RE: CPD Project #1808-026-SUB1 – Responses & Revisions

This letter is in regards to corrections and revisions for the project at 6600 82<sup>nd</sup> Ave SE, 98040. Please review this document with the re-submitted (SUB2) plan set.

1/4"=1'-0" MEZZANINE LEVEL PLAN / ROOF PLAN
1808A-FR02.dwg

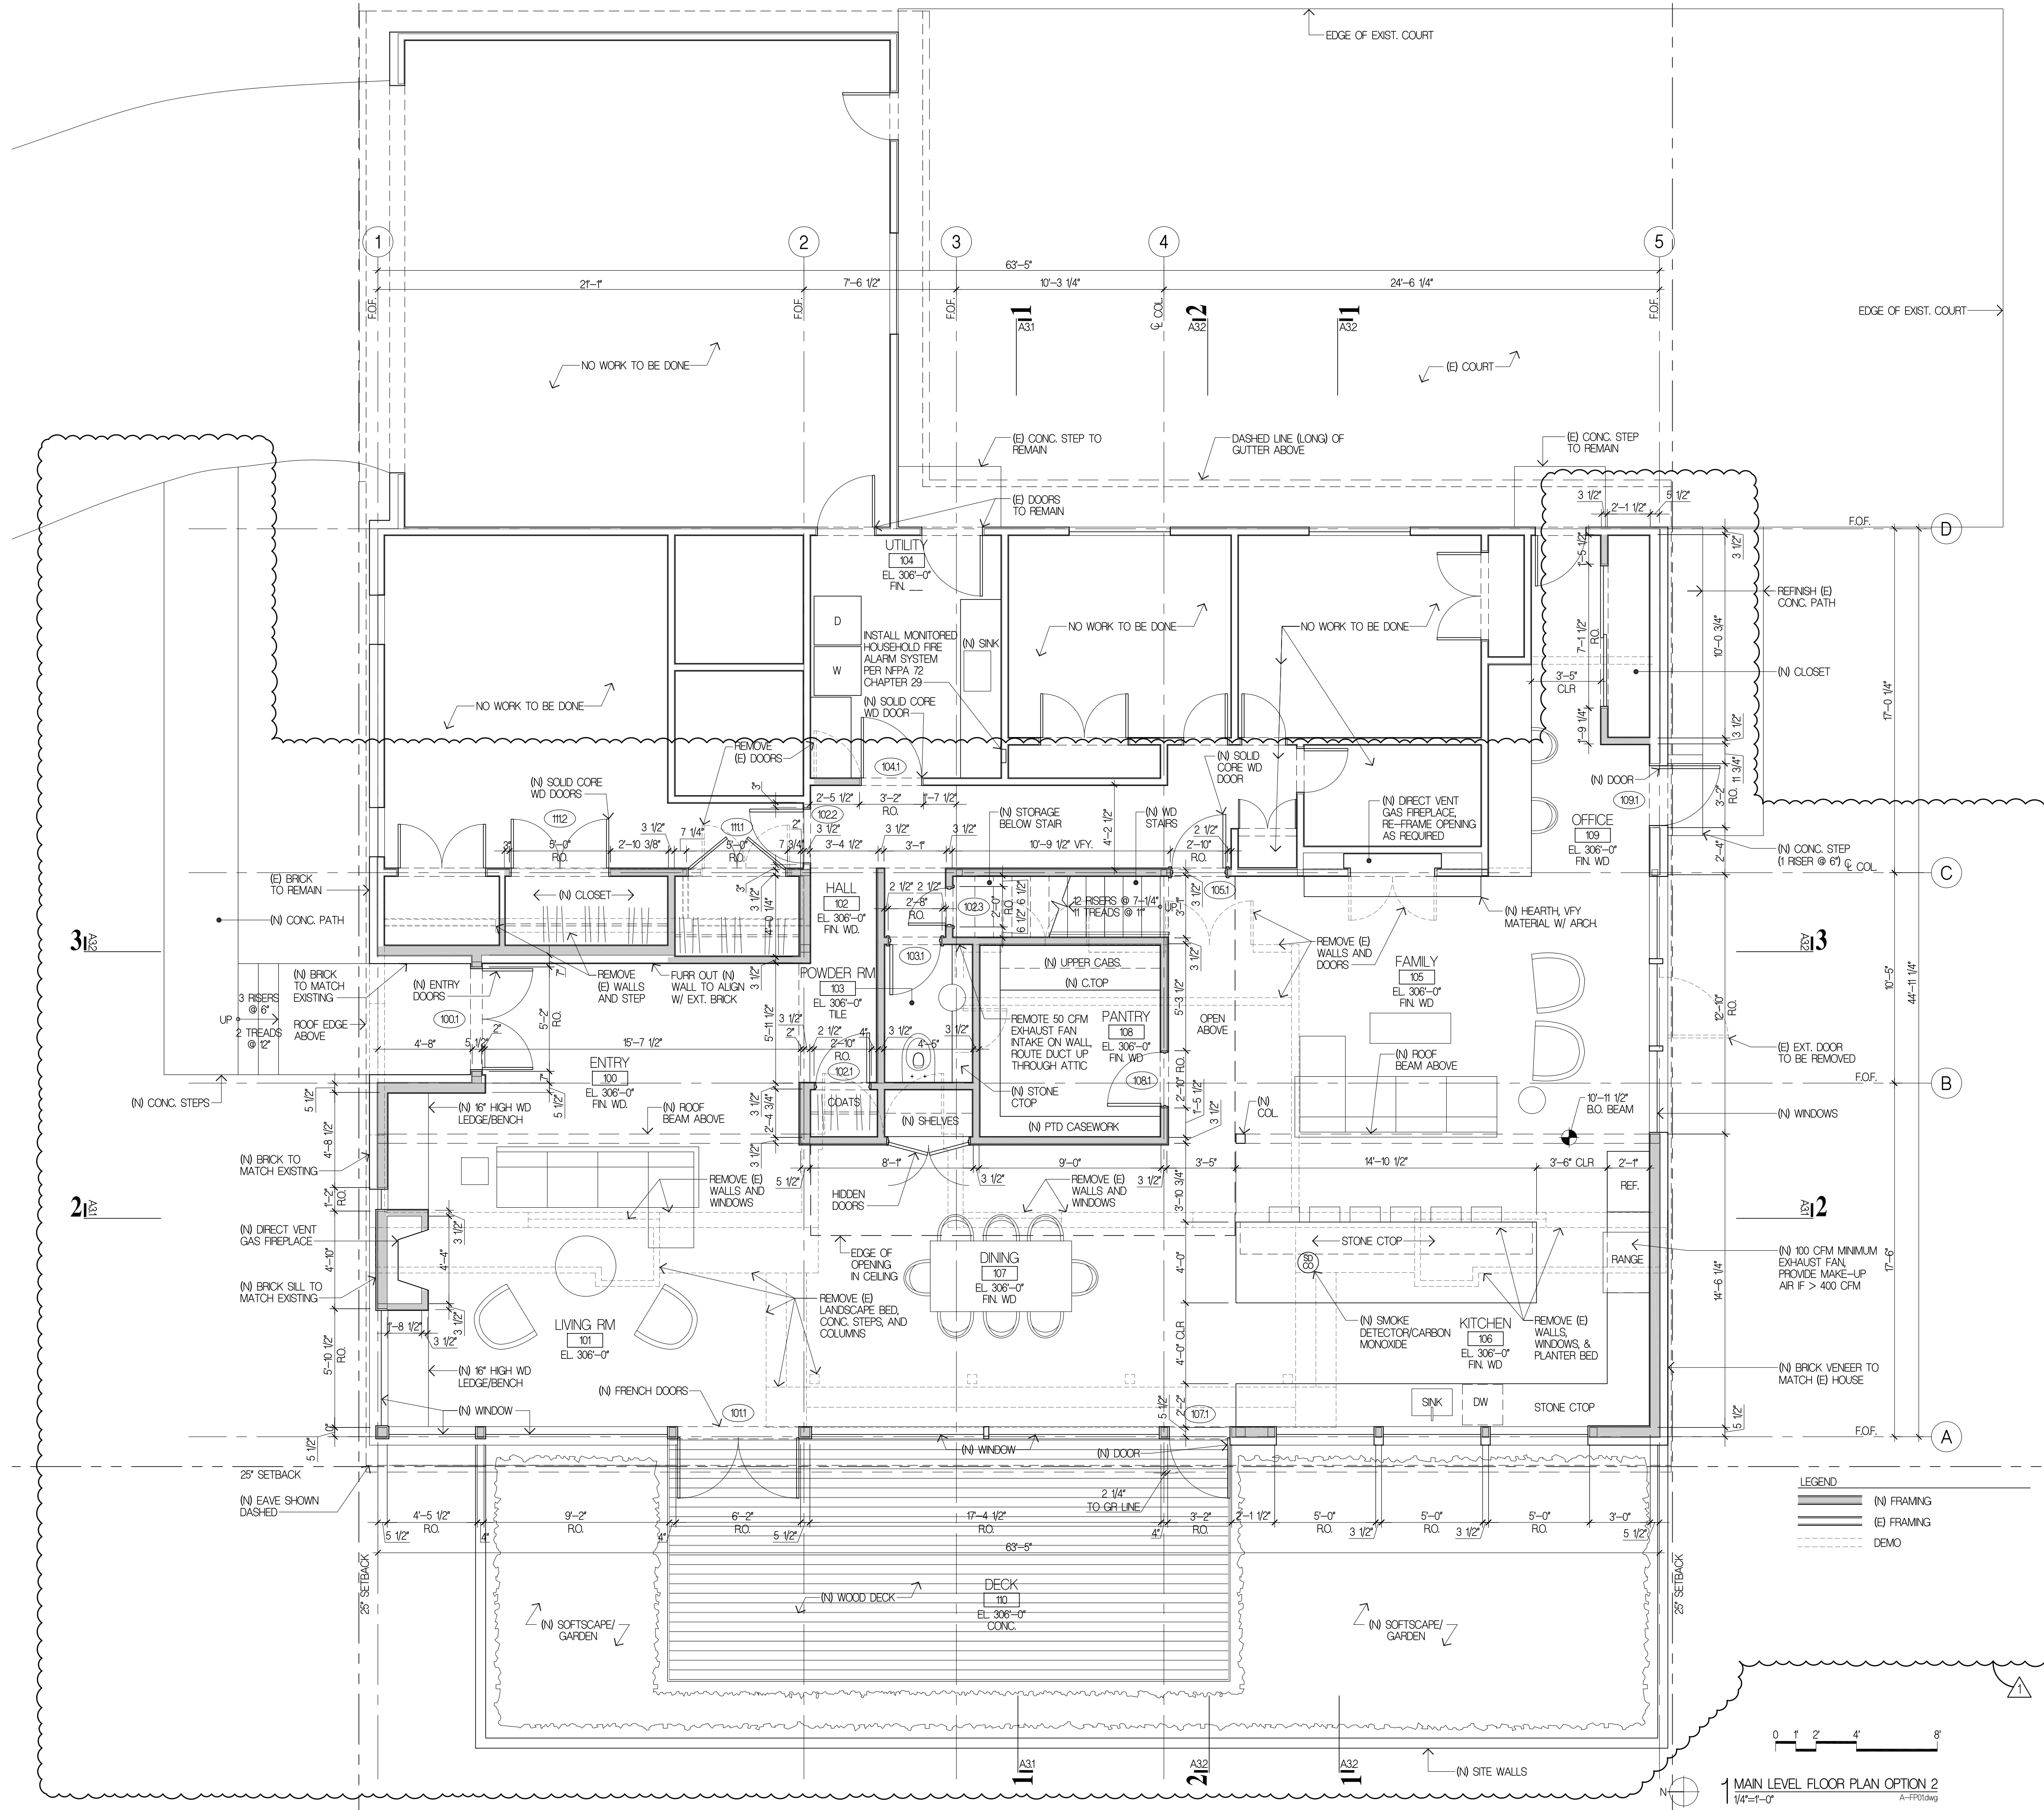
- Size of upper floor greatly reduced
- Roof size and volume greatly reduced

A1.1

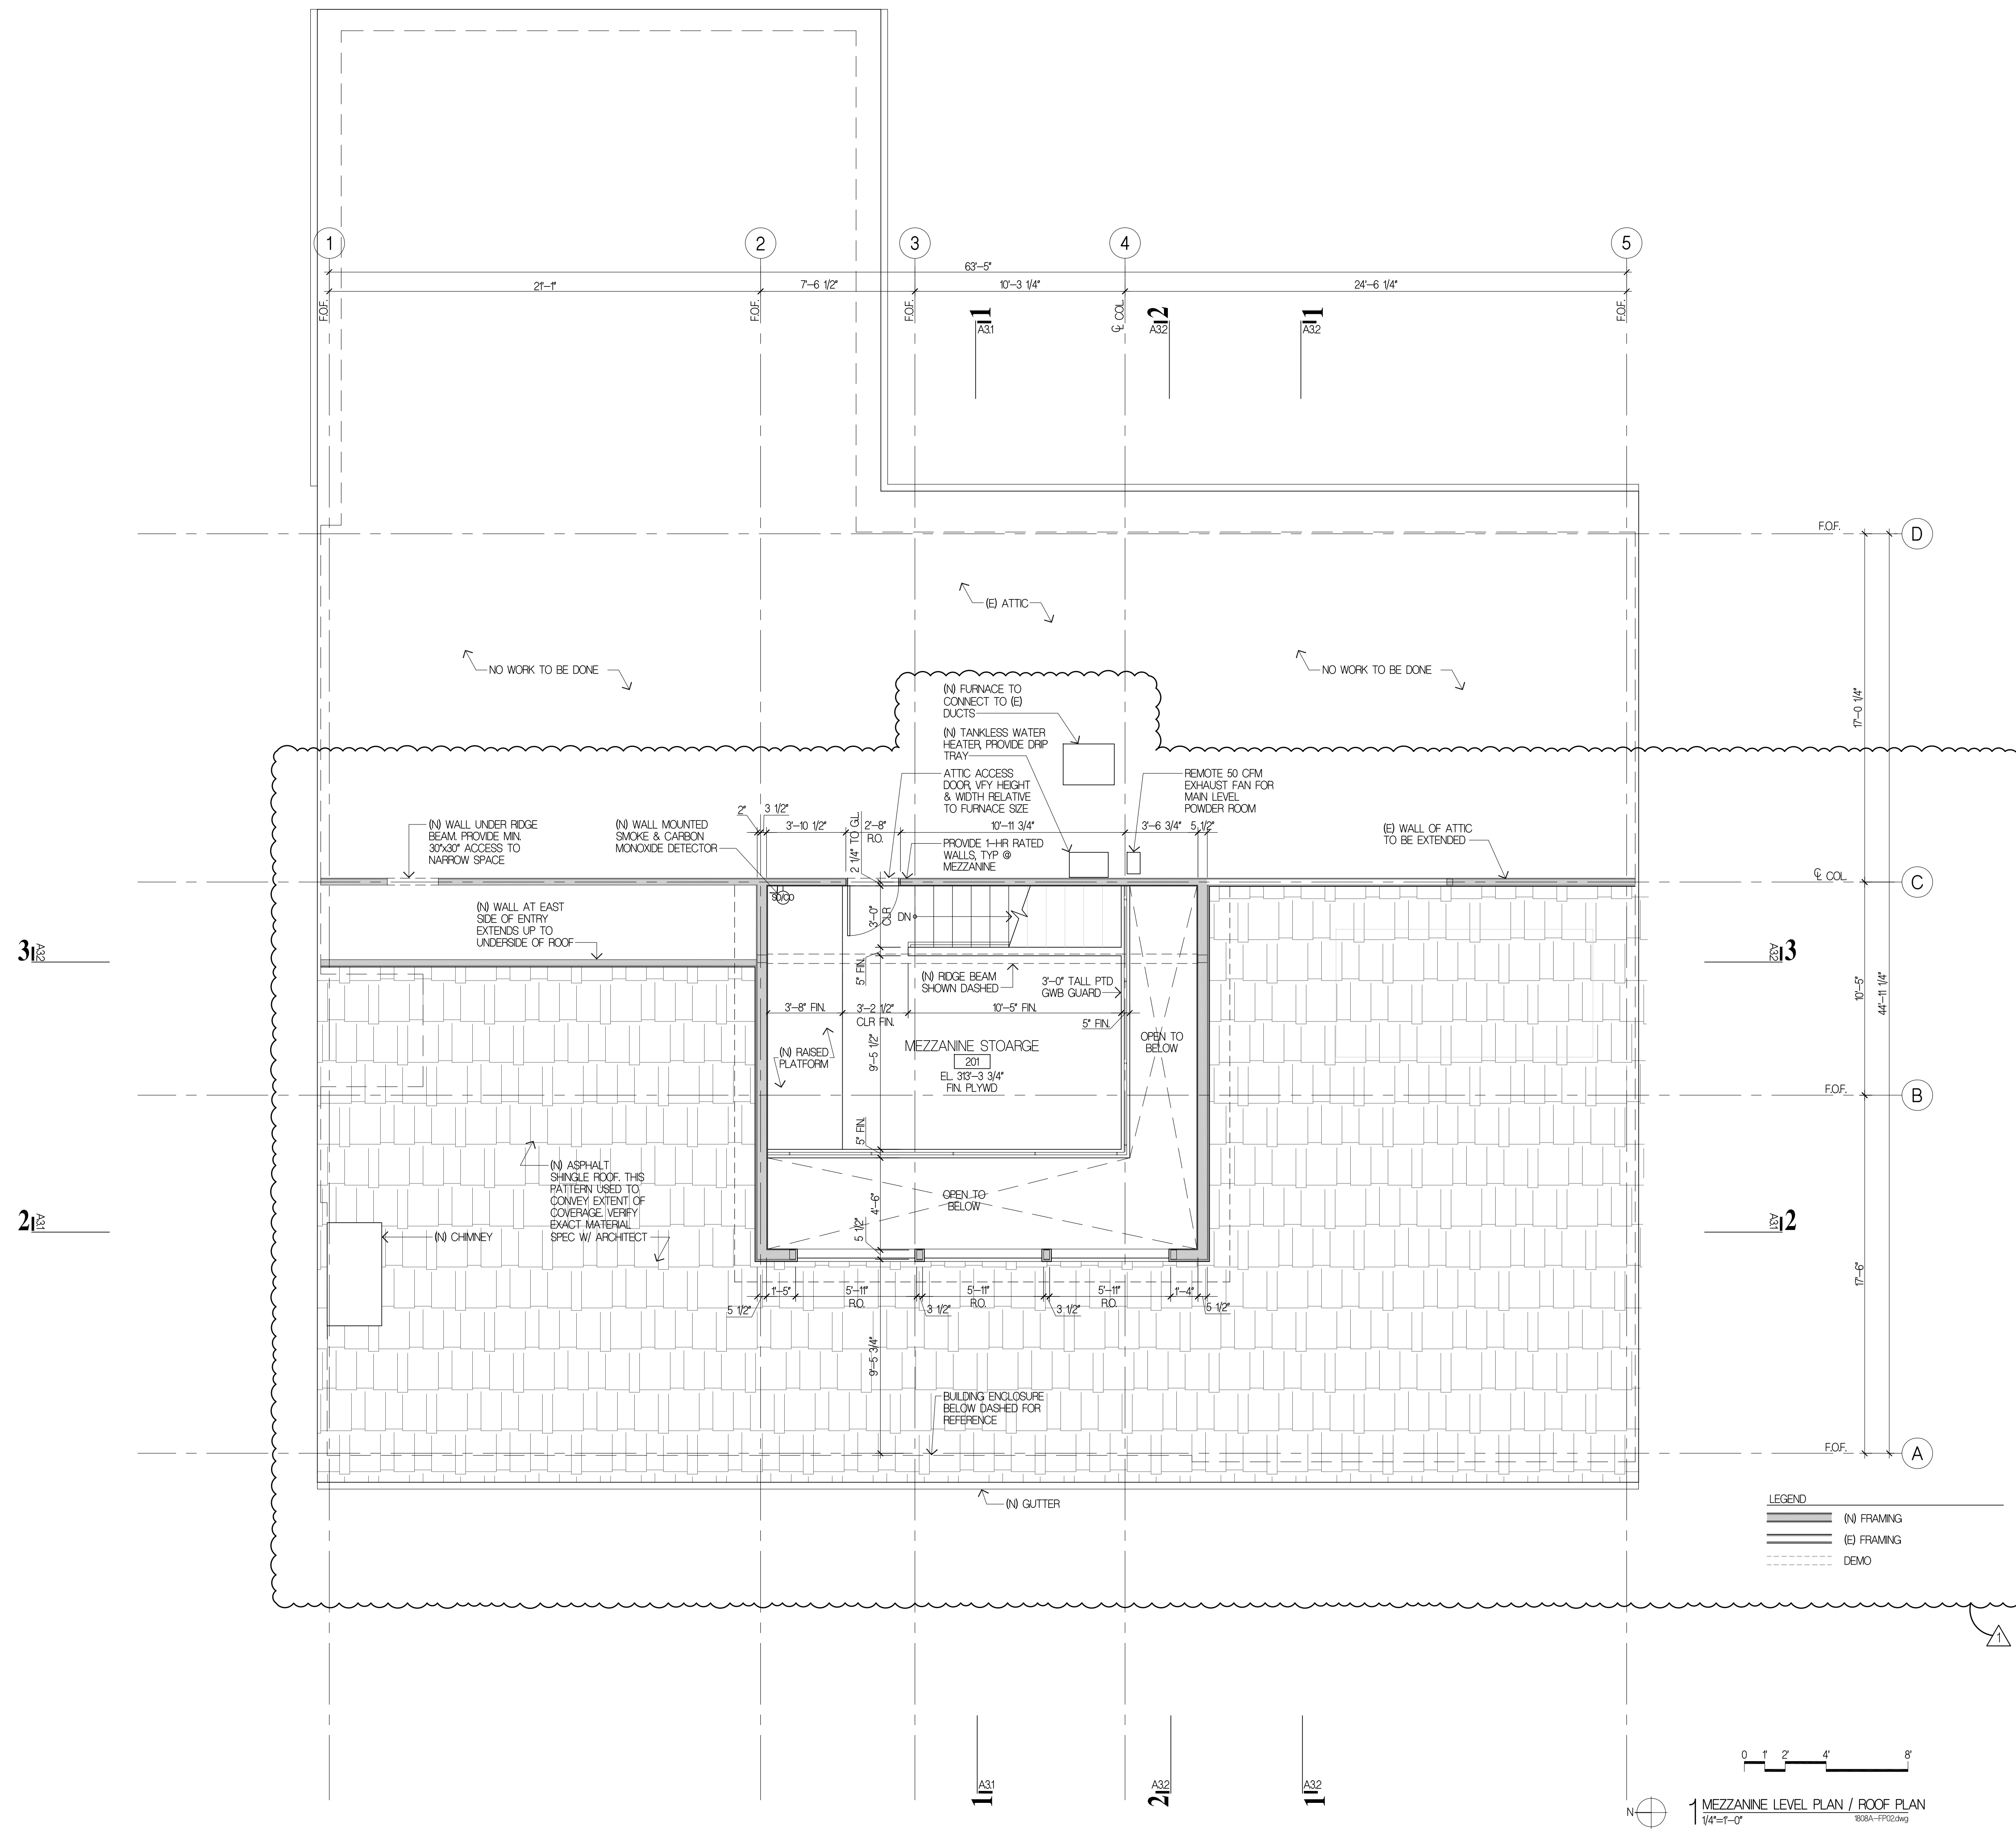
- Proposed spaces at west reorganized to accommodate new design
- New entry + path at north
- New deck + garden at west
